EN010170 GREENHILL SOLAR FARM

APPLICATION BY GREEN HILL SOLAR LTD for an Order Granting Development consent for the Green Hill Solar Project pursuant to The Planning Act 2008.

DECEMBER 2025 WRITTEN REPRESENTATION OF

SARAH BOOL MP, Member of Parliament for South Northamptonshire

Title: Figure 8.9.6 Augmented
Zone of Theoretical Visibility (ZTV)
of Full Scheme at Green Hill BESS
Revision A

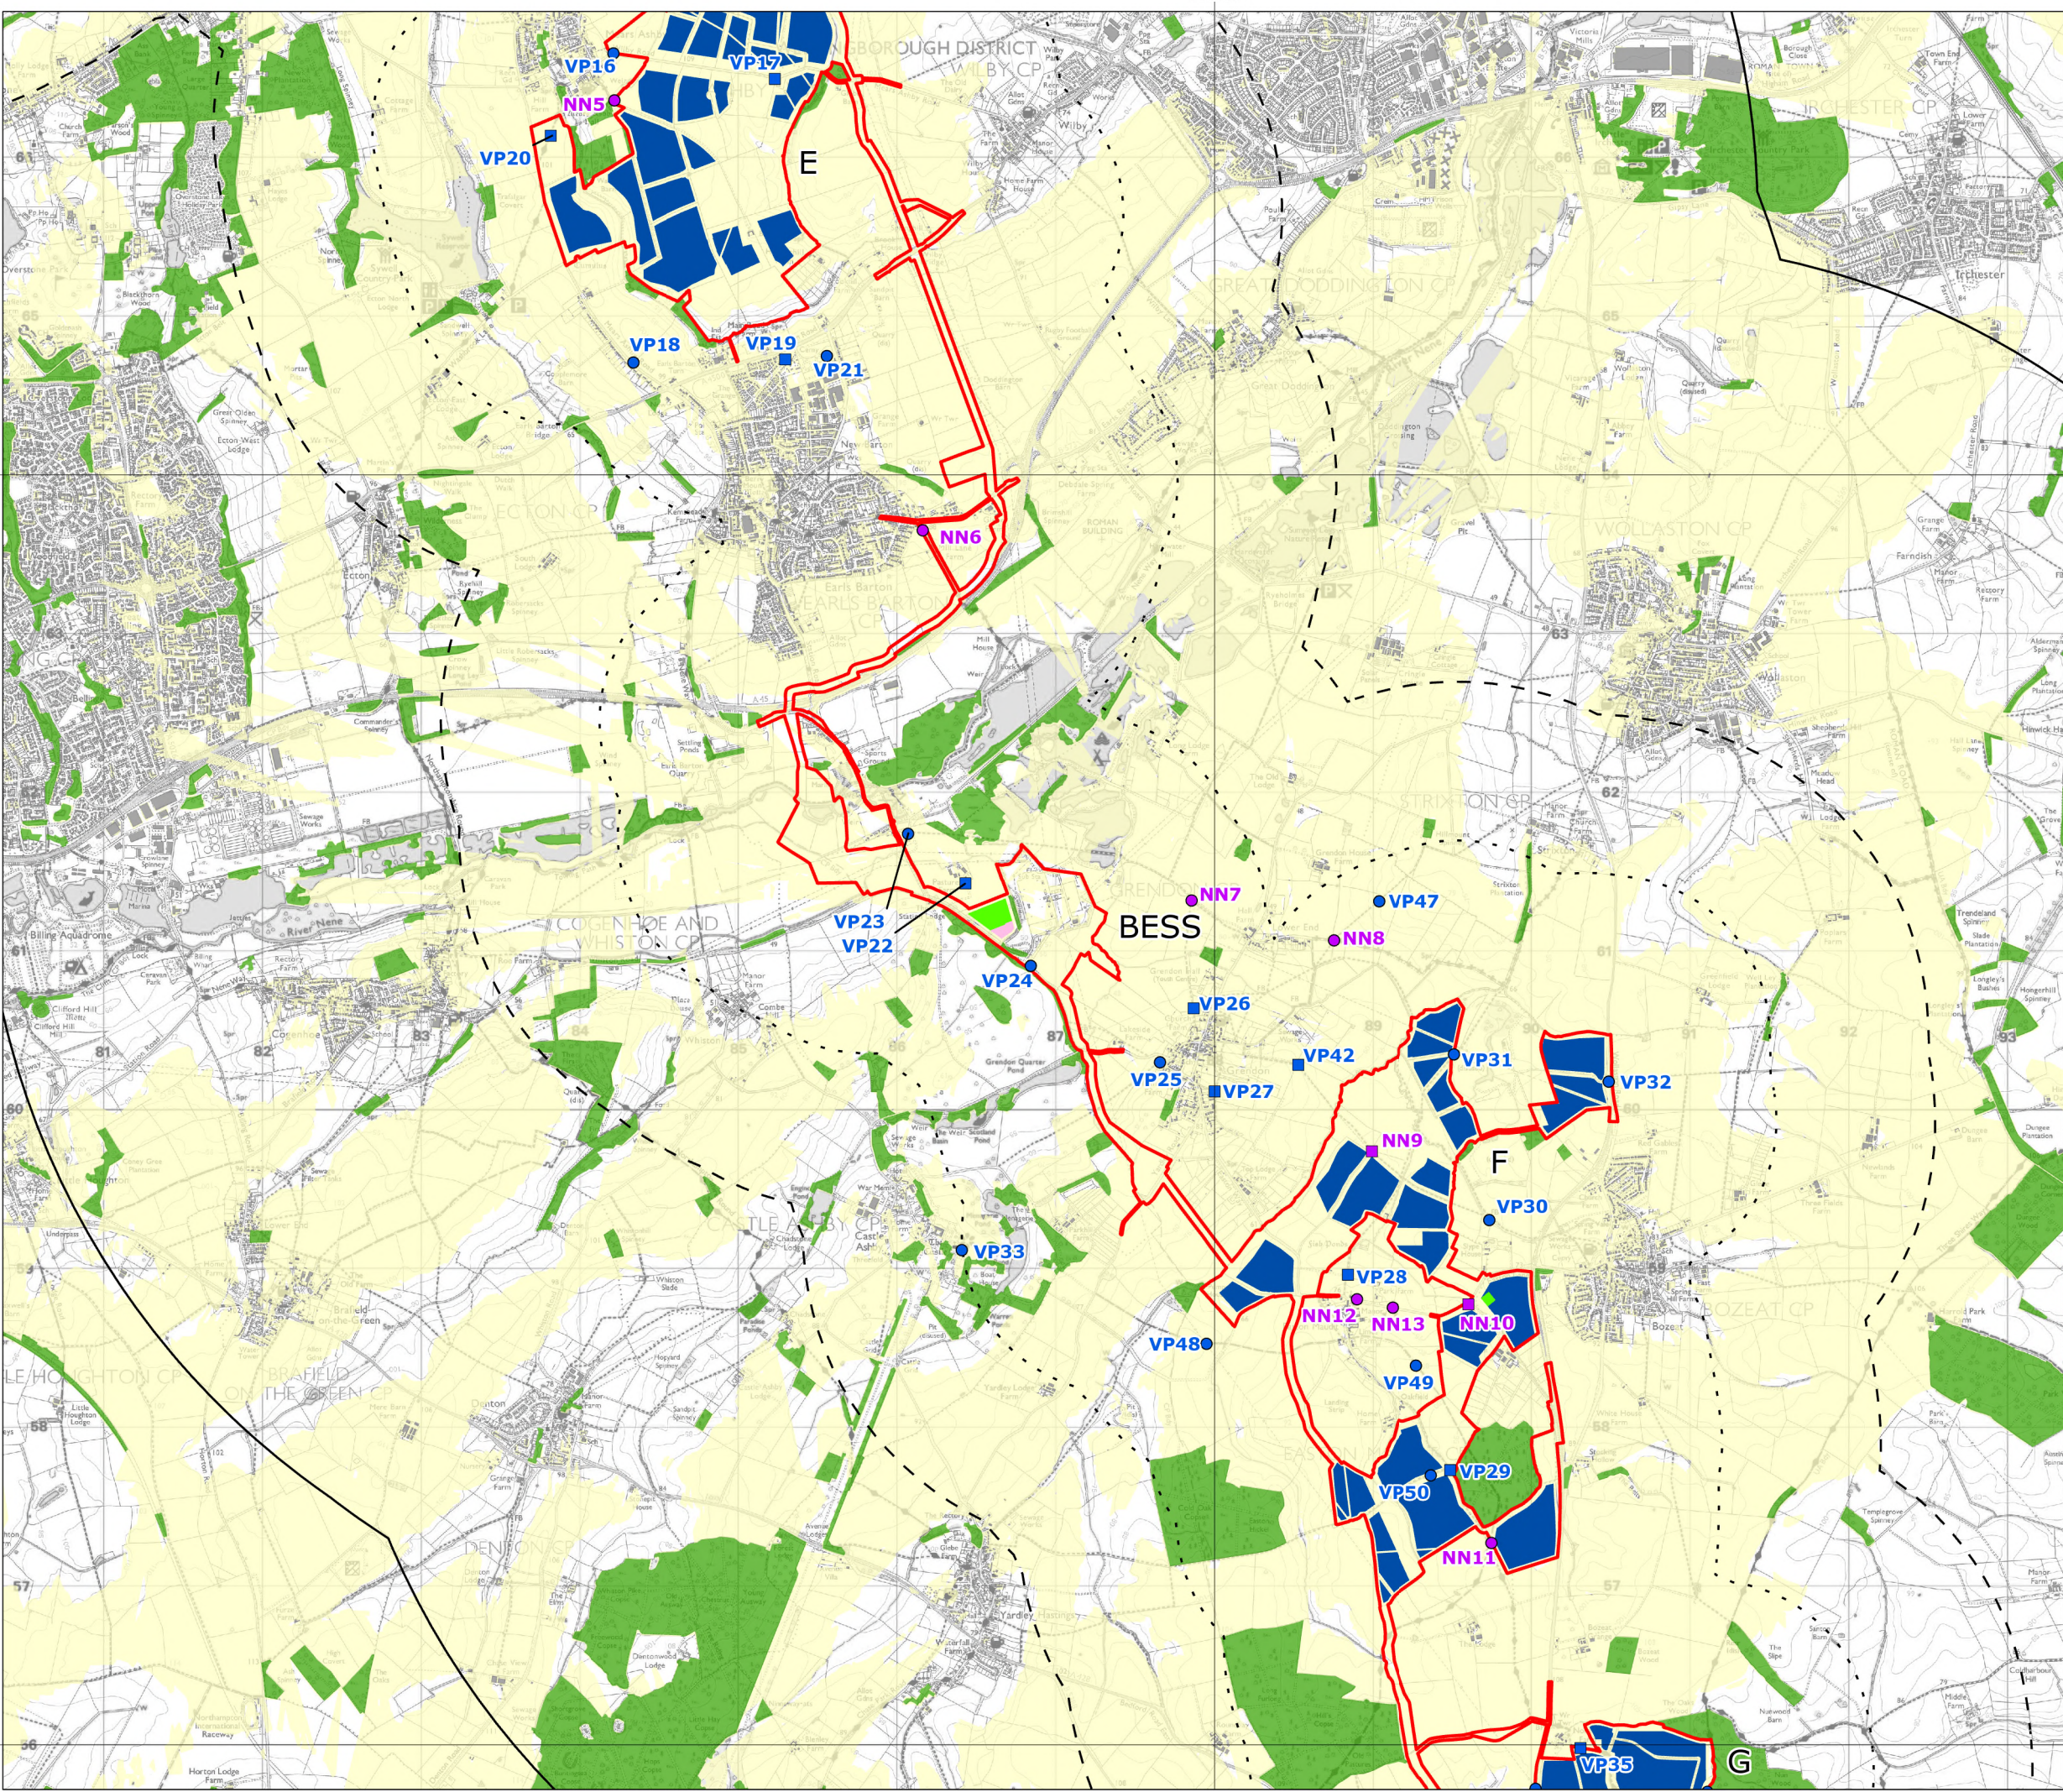
The final design of the solar panels is not defined in the DCO. Initial presentations by the applicant showed low-level panels but previous developments designed by Lanpro, who I am led to believe is the proposed designer for Green Hill Solar, have had panels as high as 4.5m. The only information available on this front is that it will comprise of either 3.5m high panels fixed east to west, or 4.5m rotating panels or a combination of both. The fact that this design is not part of the consideration given the impact it will have, avoids the necessary scrutiny of the scheme.
